Memorandum

To: Jolene Wolfley and Jay Rodenbeck
From: Jacqueline Fishman, AICP
Date: September 11, 2023
Re: Major Amendment - PR-2021-005689; SI-2023-01391

This memorandum accompanies the Major Amendment for the project located at 7050 Constitution that was approved by the Development Facilitation Team (DFT) on August 30, 2023. The Site Plan is ready for final sign-off with the following changes having been made to the Site Plan, Landscape Plan, and Building Elevations:

LANDSCAPE PLAN
SCALE: 1"=10'-0"
0 5' 10' 20' NORTH

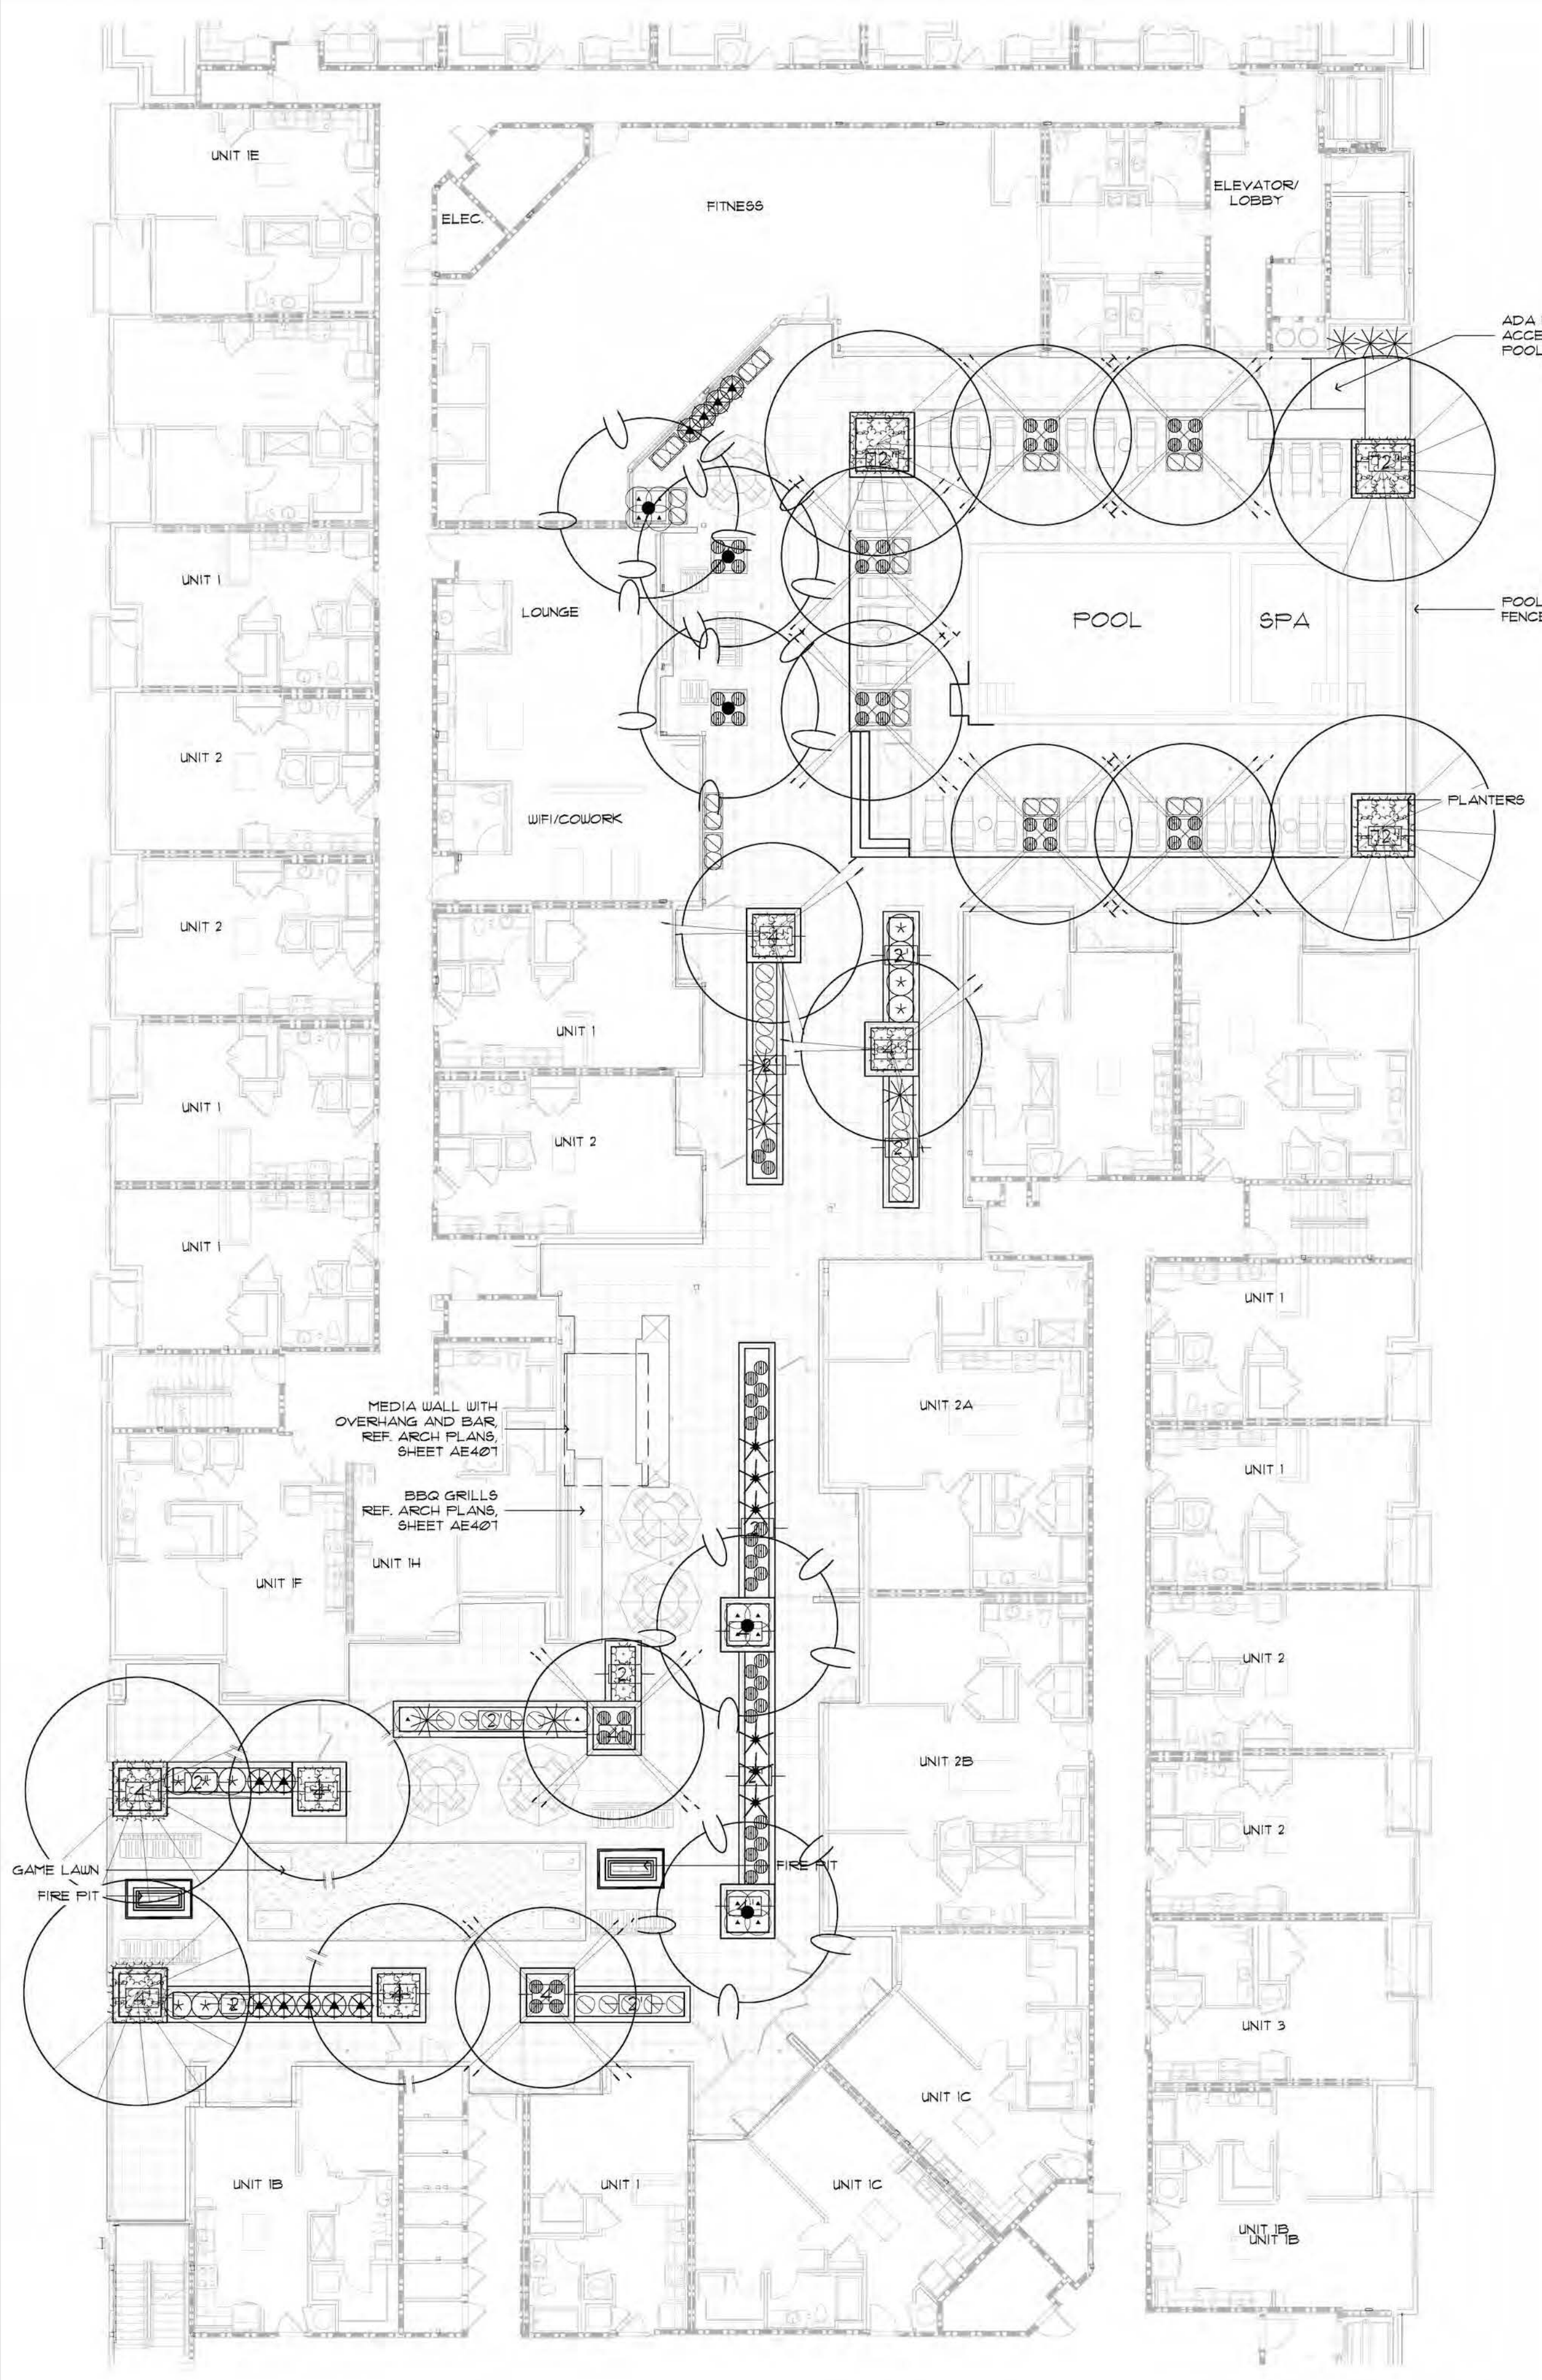
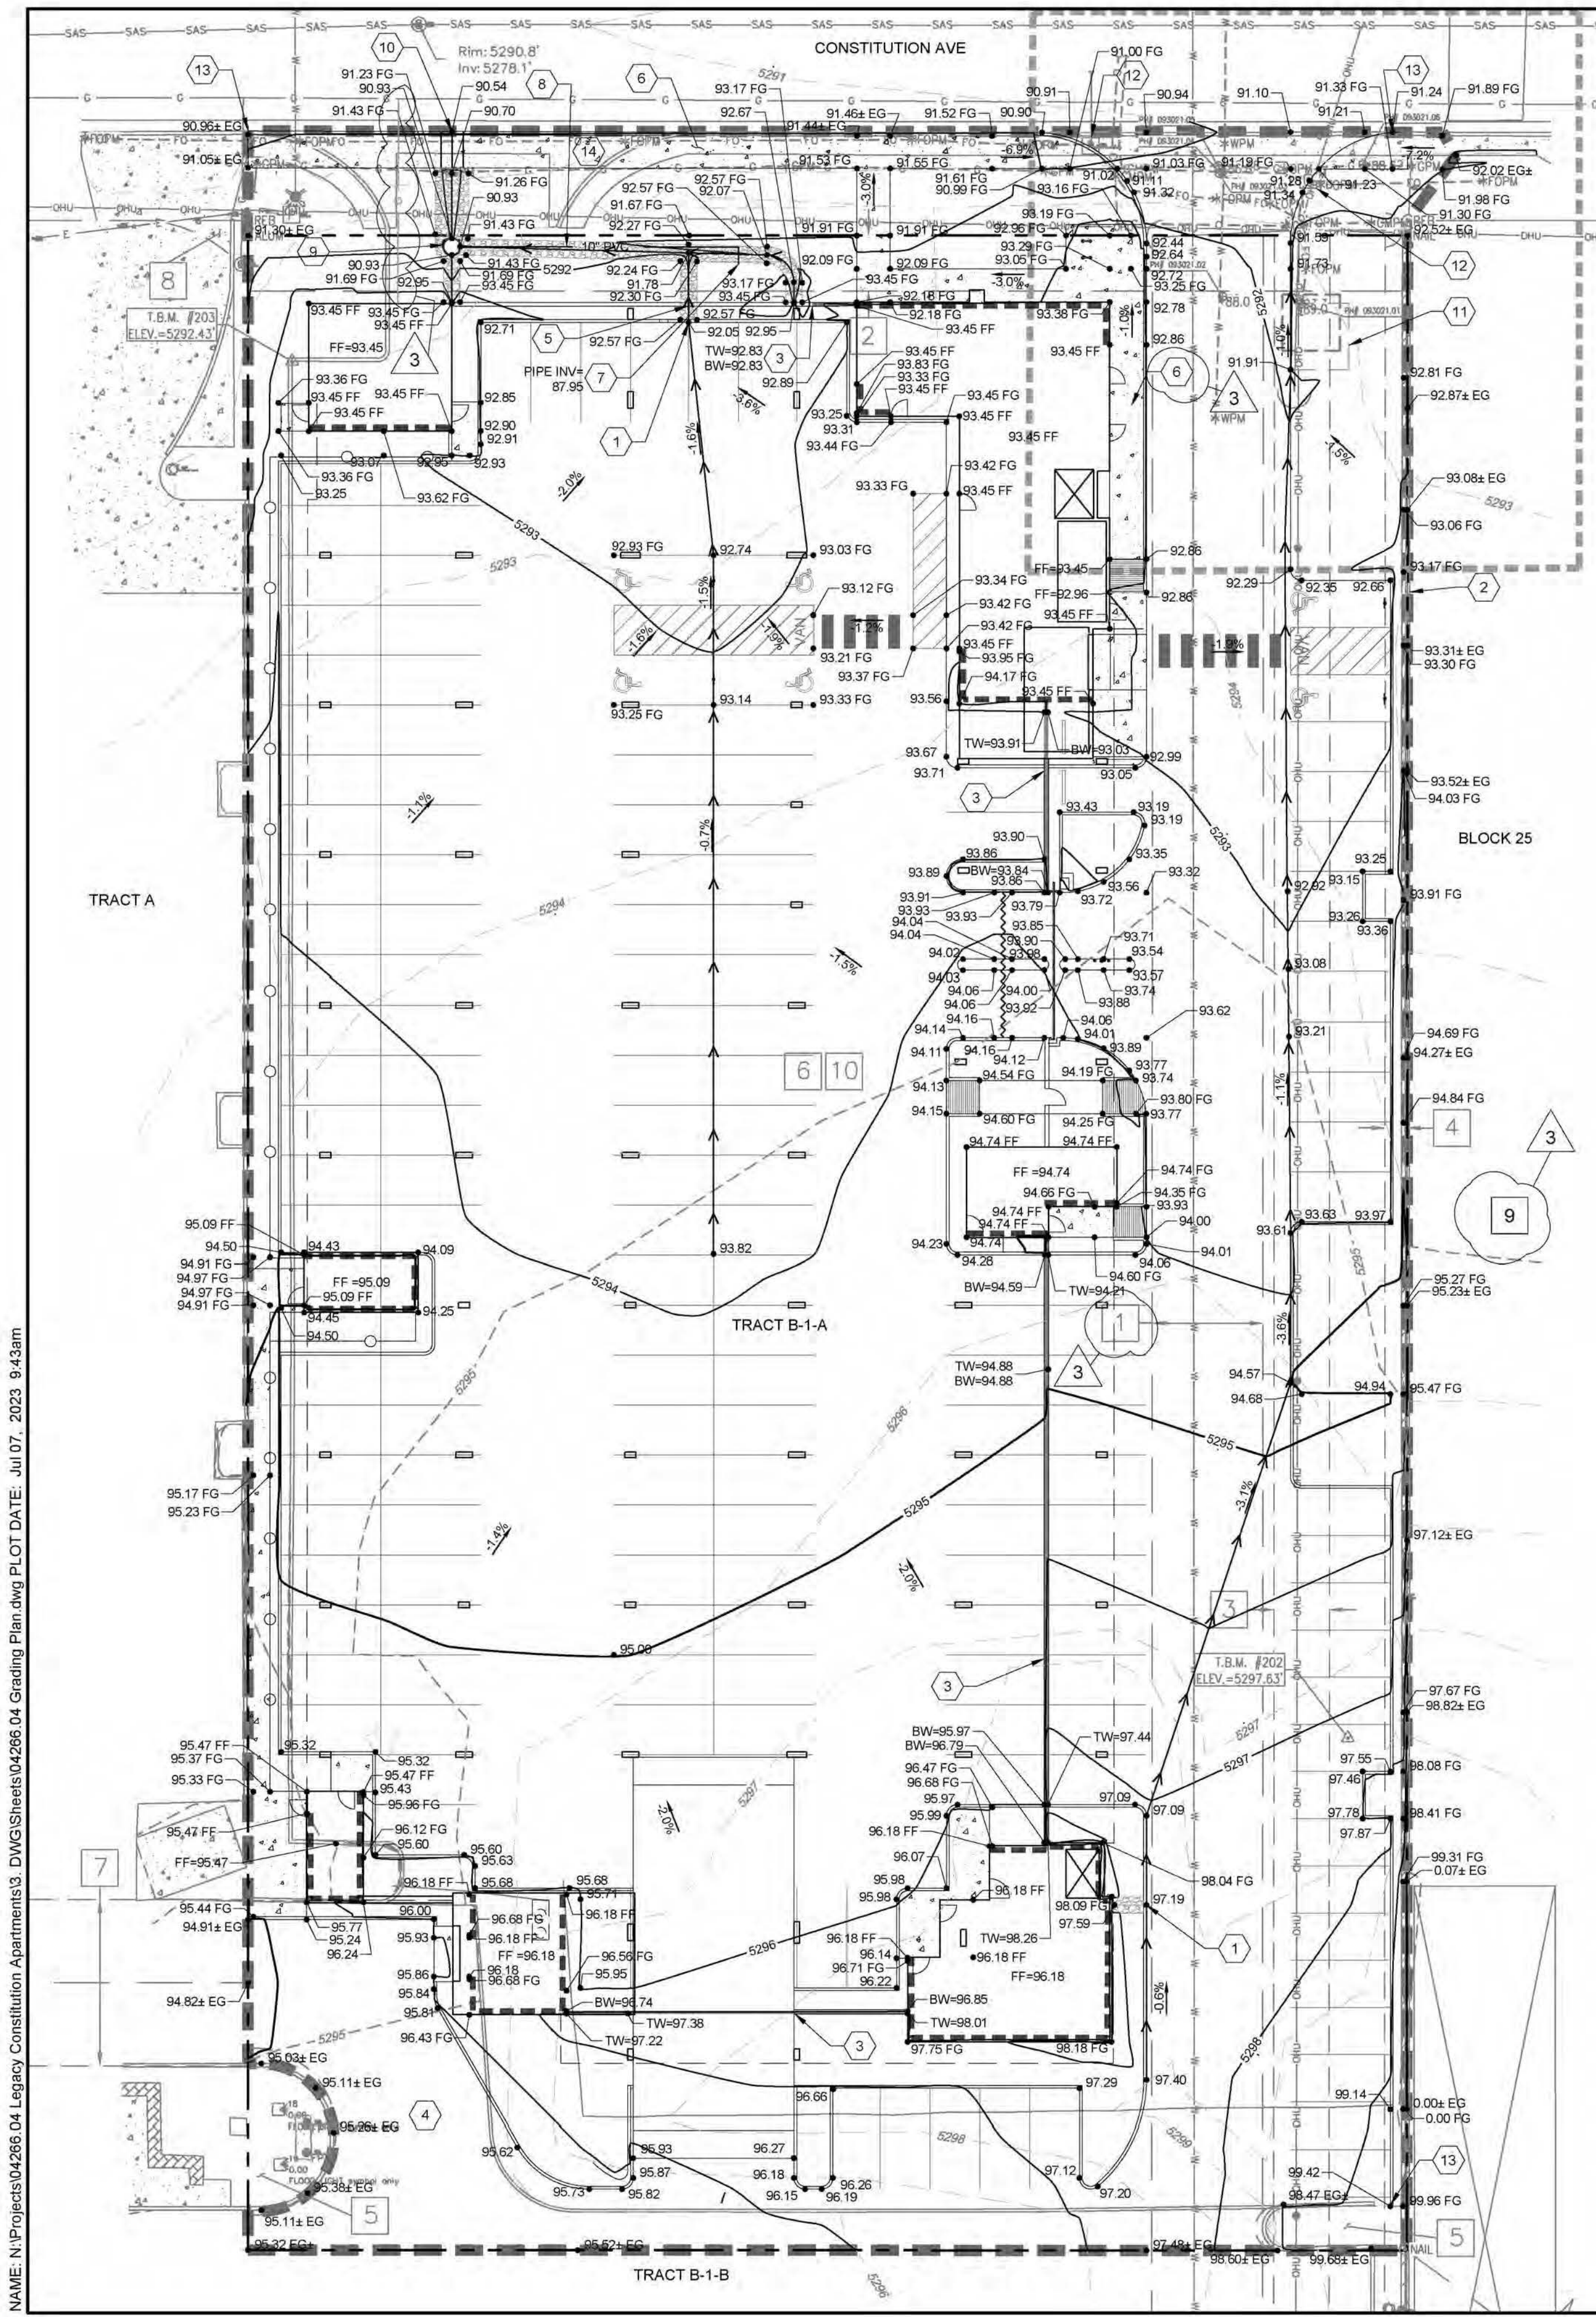
- 6) The blade sign on the Building Elevations has been changed to project a maximum of 30 inches from the building, per Table 5-12-2.
- 7) The second floor Landscape Plan, sheet L1.2, has been added to the Site Plan set of drawings showing plant location, plant palette, and quantities, and the Landscape Plan, sheet L1.1, has been revised to reflect only the plant palette and quantities on the ground for clarity purposes.
